Application No: BR/55/20/PL
Site Address: Abbots Lawn Sylvan Way Bognor Regis PO21 2RS
Description of works: Proposed first and second floor extensions.

Thank you for your internet representation made on 14th May 2020 which has been recorded as an objection with the comments as follows:

Proposed East Elevation

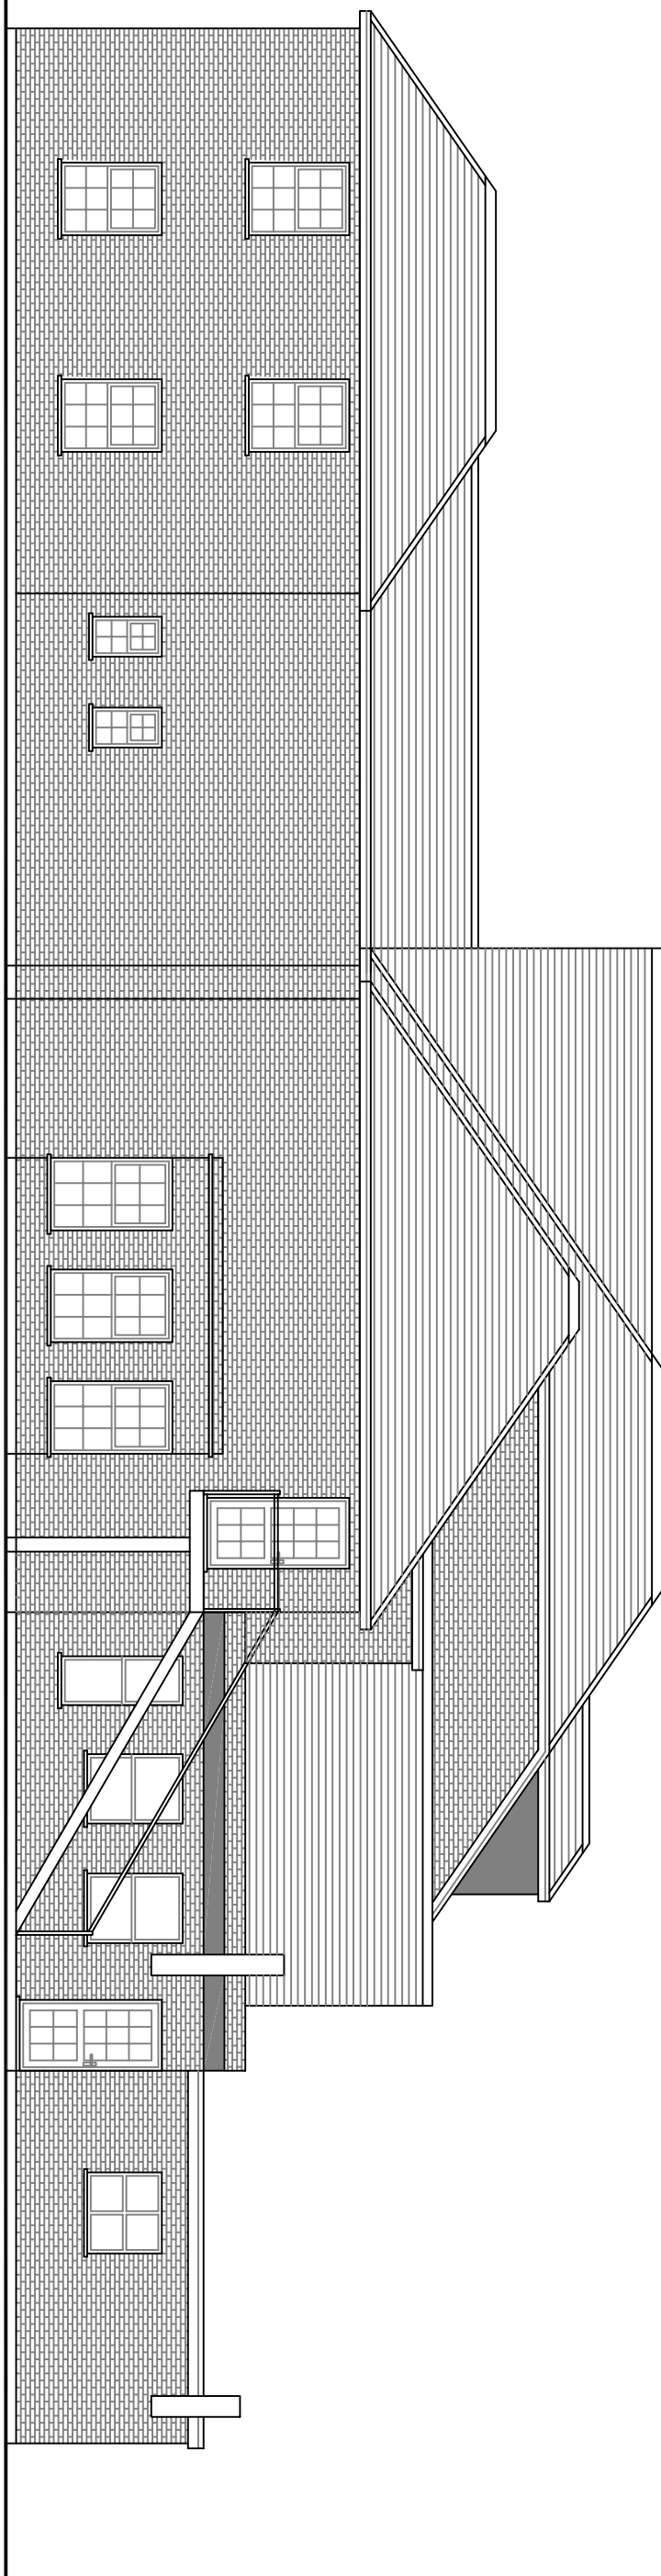
I object to the proposed Abbots Lawn extension rear of my property. At present there are no windows on the east side overlooking my property. With this development I will be totally overlooked with complete loss of privacy of my bedrooms, bathroom, kitchen and sitting room. I will also lose sun and light in my small garden which is adjacent to Abbots Lawn. I urge you to dismiss this application.
